# CITY OF ALBUQUERQUE

June 19, 2017

**RE: McMahon Market Place Lots 9C&D**  
**Grading and Drainage Plan**  
**Stamp Date: 6/13/17**  
**Hydrology File: A11D011F**

SHEET NO:
C-1

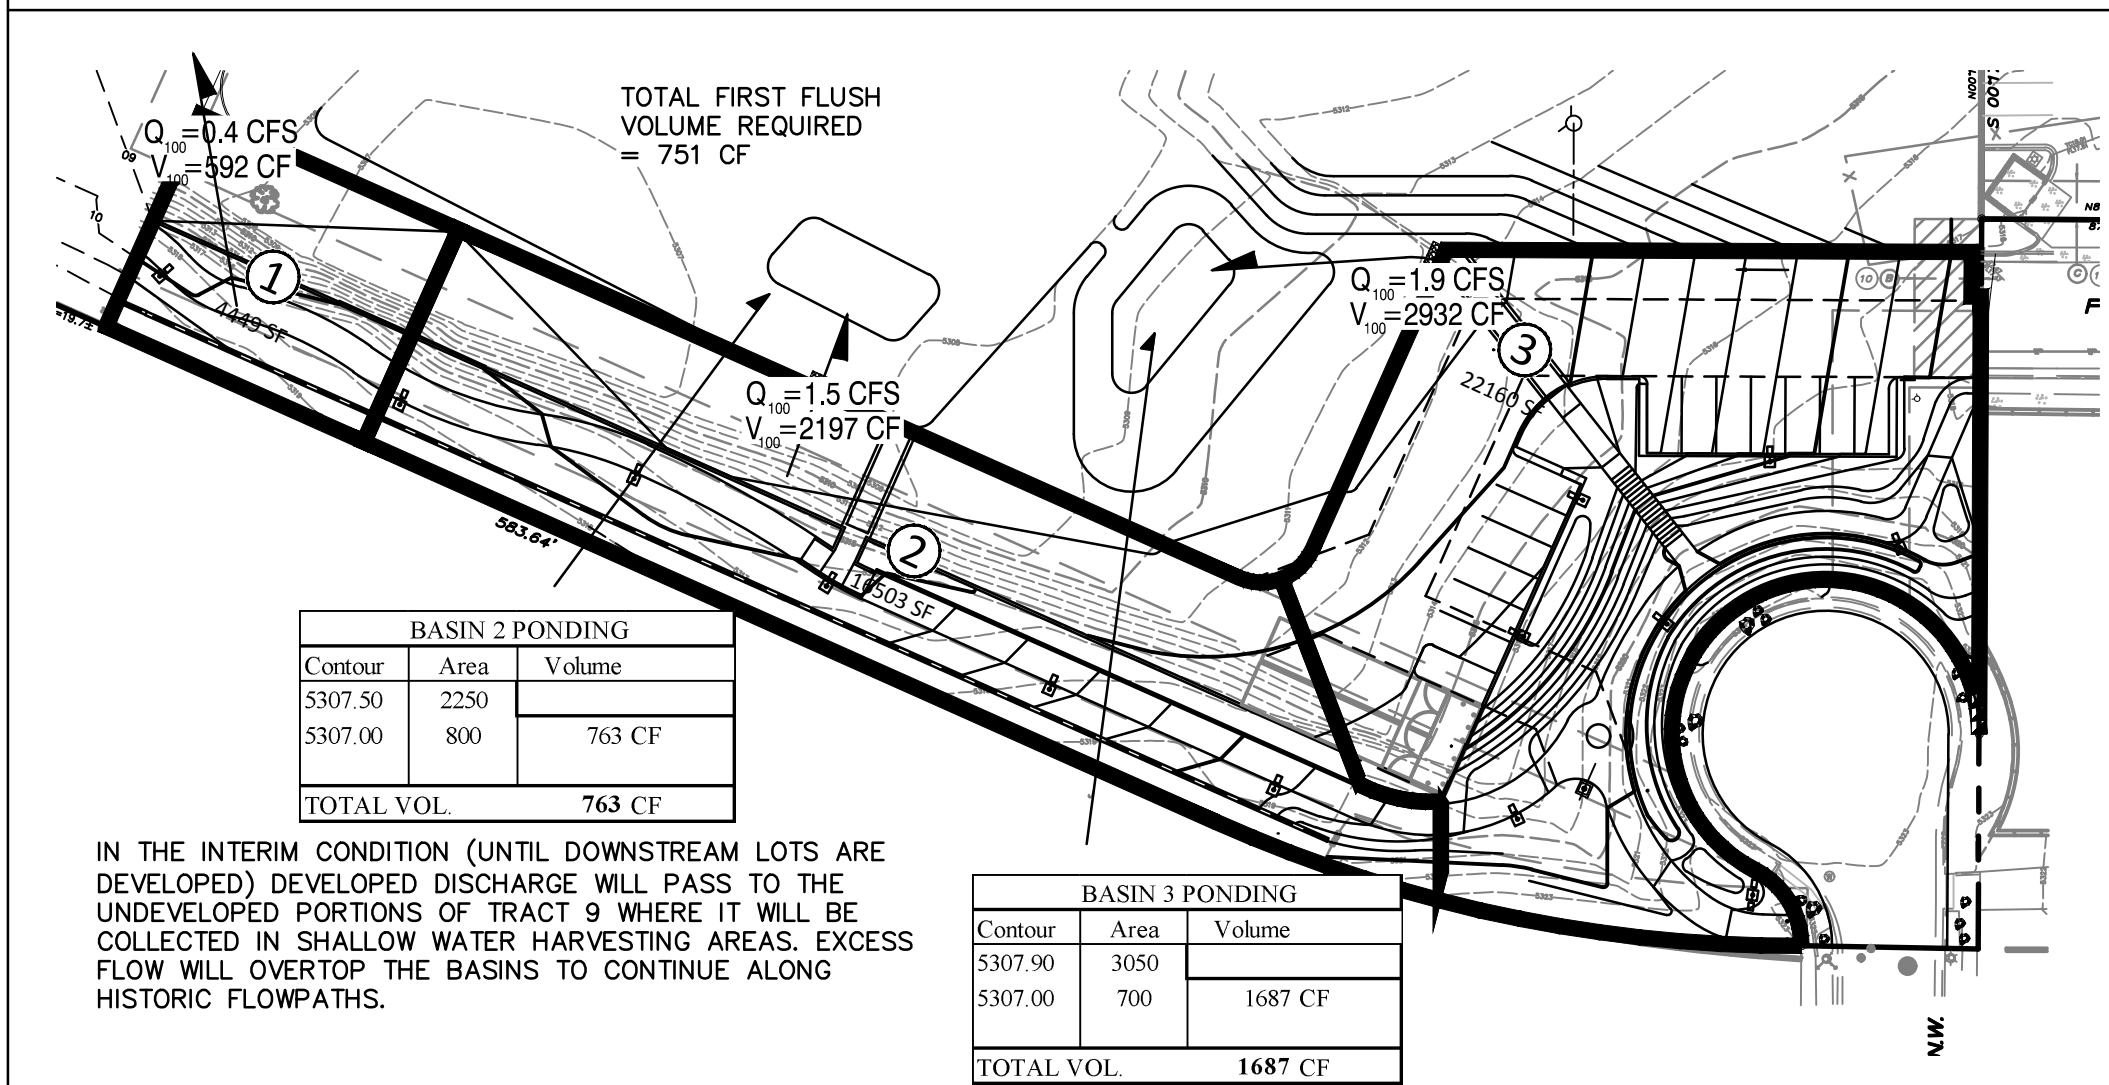
2. On Sheet C-1. On the Vicinity Map, please show the site area from the Taco Bell site to Fineland Drive.
3. On Sheet C-1. Please show the existing Taco Bell development, about 25 feet min. into the site. Please show the existing retaining wall with top of wall and bottom spot elev., existing sidewalk, curb, and hatch the existing pavement.

4. On Sheet C-1. Please provide a cross section of the retaining wall. This section should include the existing block wall along the property line, the proposed drive, and the proposed grades on the other side of the drive.

5. On Sheet C-1. It appears that the proposed retaining wall is taller than 8 feet high in a spot. The maximum height for a retaining wall is 8 feet without an approved variance. This can be handled with changing the spot elevation at the bottom of the wall so it does not go past the 8 feet height maximum. Please clarify.

6. On Sheet C-1. At both of the proposed curb cuts, there appears to be patch of rip rap or gravel. If so, then please label it and give an area for them.
7. On Sheet C-2. Please label both of the basins in the Drainage Basin Map.
8. On Sheet C-2. Please enlarge both basins' ponding charts so that it is legible. These also should be placed adjacent to the Basin Map.
9. On Sheet C-2. Please show the basins' calculations for the 100 year 6 hour storm along with the overall development calculations which you provided.
